Subject: EES comments on Response to Submissions for Adaptive reuse of the Royal Hall of Industries – SSD-9726 – 1 Driver Avenue, Moore Park

Subject: EES comments on the Response to Submissions for adaptive reuse of the Royal hall of Industries – SSD-9726 – 1 Driver Avenue, Moore Park

The Environment, Energy and Science Group (EES) has reviewed the following documents:

Trees for Removal - 4
Trees to be Retained and Protected - 56
Proposed Trees on Ground Floor - 23

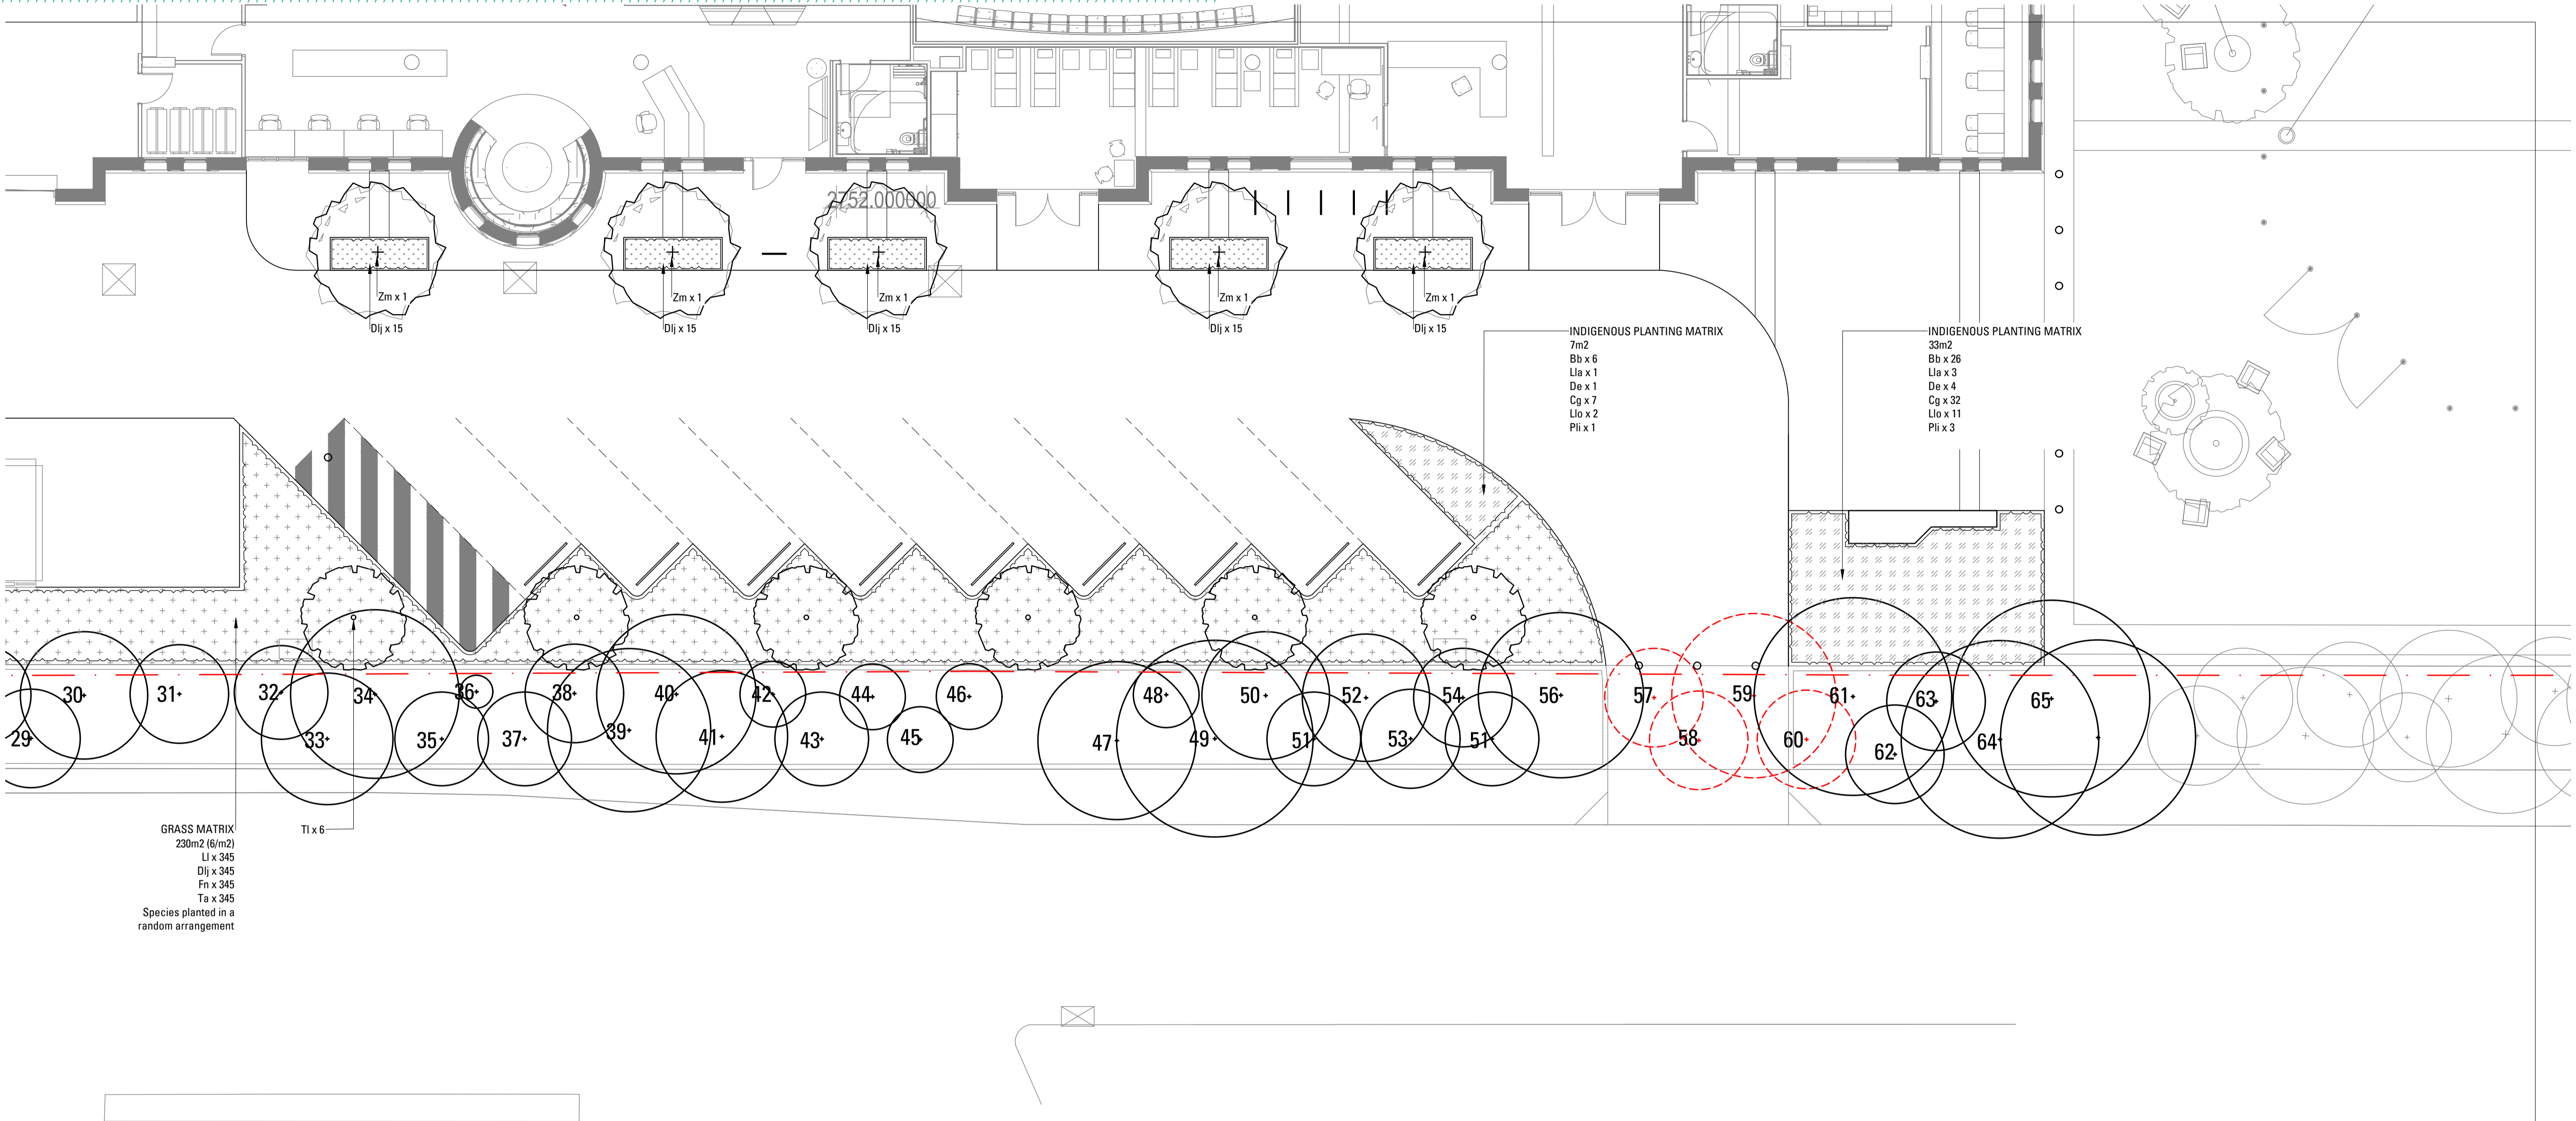
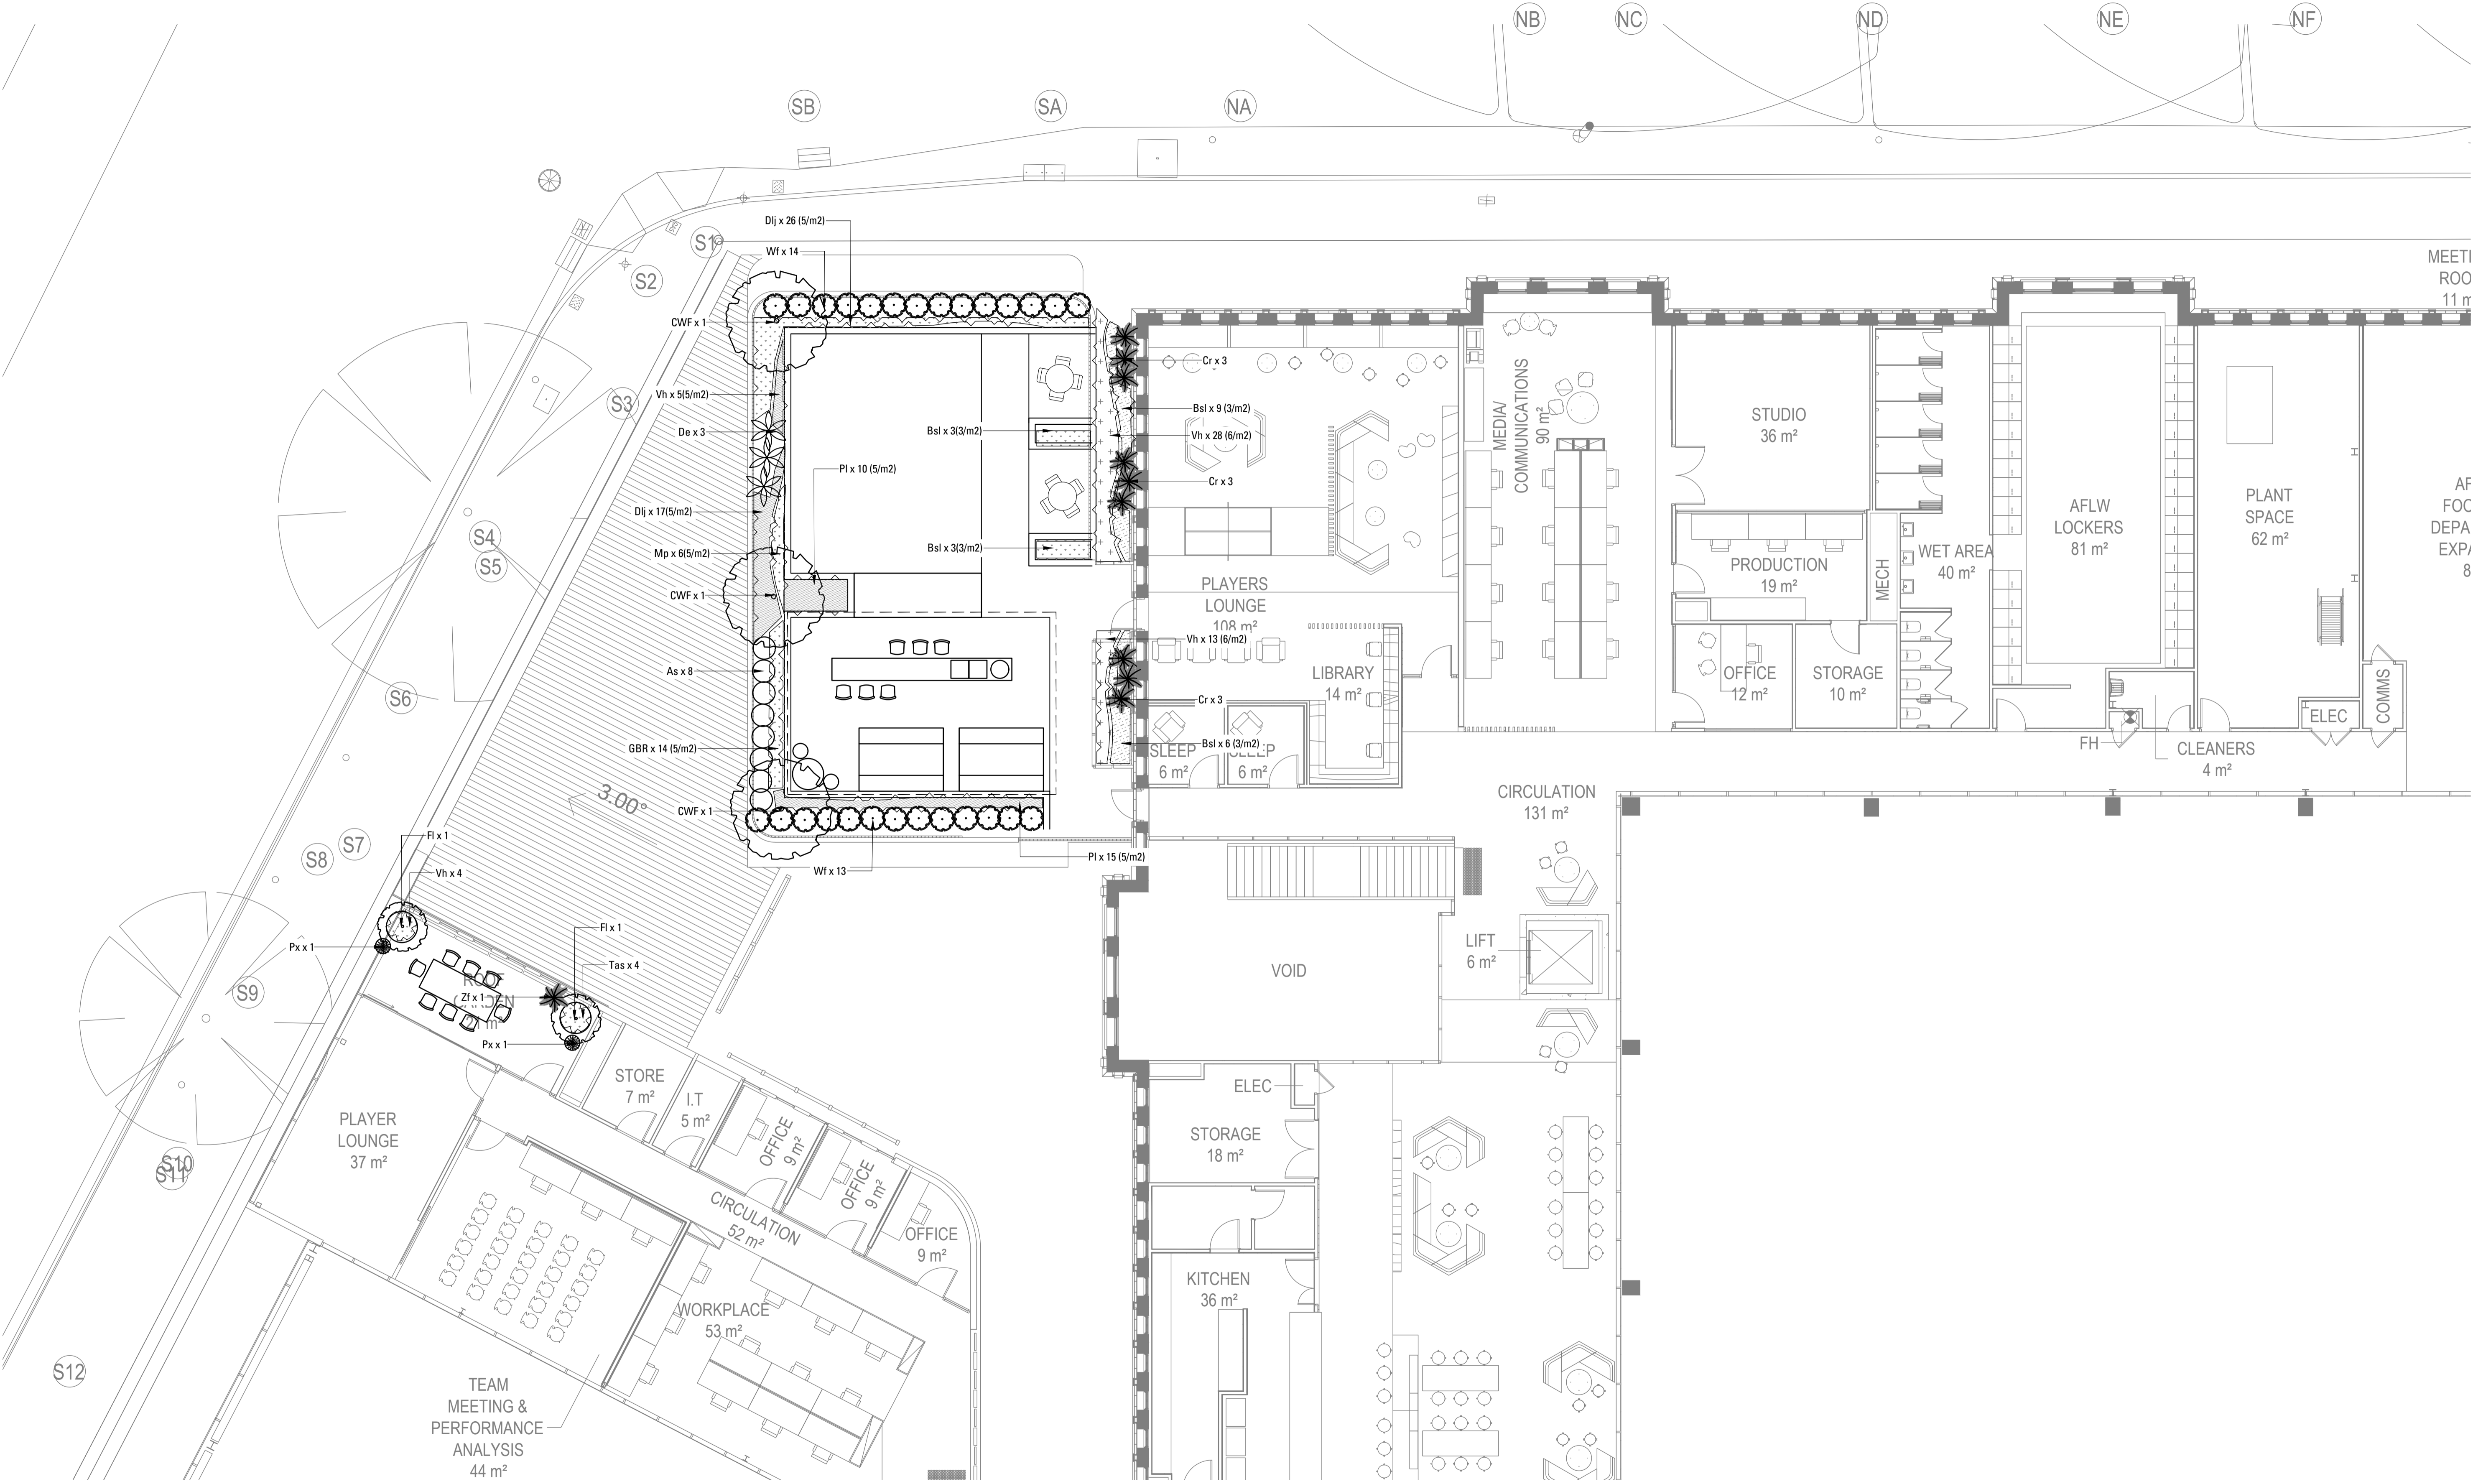
The RTS notes the number of trees proposed to be removed has reduced from seven trees to four Spotted Gums (*Corymbia maculata*) and that the impact of removing four trees will be mitigated through the planting of 23 additional trees on ground level and 3 trees of level 1 (page 19). EES supports the proponent reducing the number of trees to be removed and increasing the number of trees to be planted.

The Swans HQ Masterplan shows deciduous trees are proposed to be planted in addition to native species. EES repeats its previous recommendations that:

- the site landscaping/planting schedule uses a diversity of local native provenance trees, shrubs and groundcover species from the native vegetation community that once occurred in this locality rather than plant exotic or non-local natives and if the project is approved, a condition of consent is included to this effect
- the landscape plan demonstrates that the plant species list comprises a diversity of local provenance native plant species.

1. Landscaping at the site shall use a diversity of local native provenance trees, shrubs and groundcover species (rather than exotic species or non-local native species) from the relevant native vegetation community that once occurred in this locality.

2. Tree planting at the site shall use advanced and established local native provenance trees with a minimum plant container pot size of 100 litres, or greater for local native tree species which are commercially available. Other local native tree species which are not commercially available may be sourced as juvenile sized trees or pre-grown from provenance seed.
3. Enough area/space must be provided to allow the planted trees to grow to maturity.
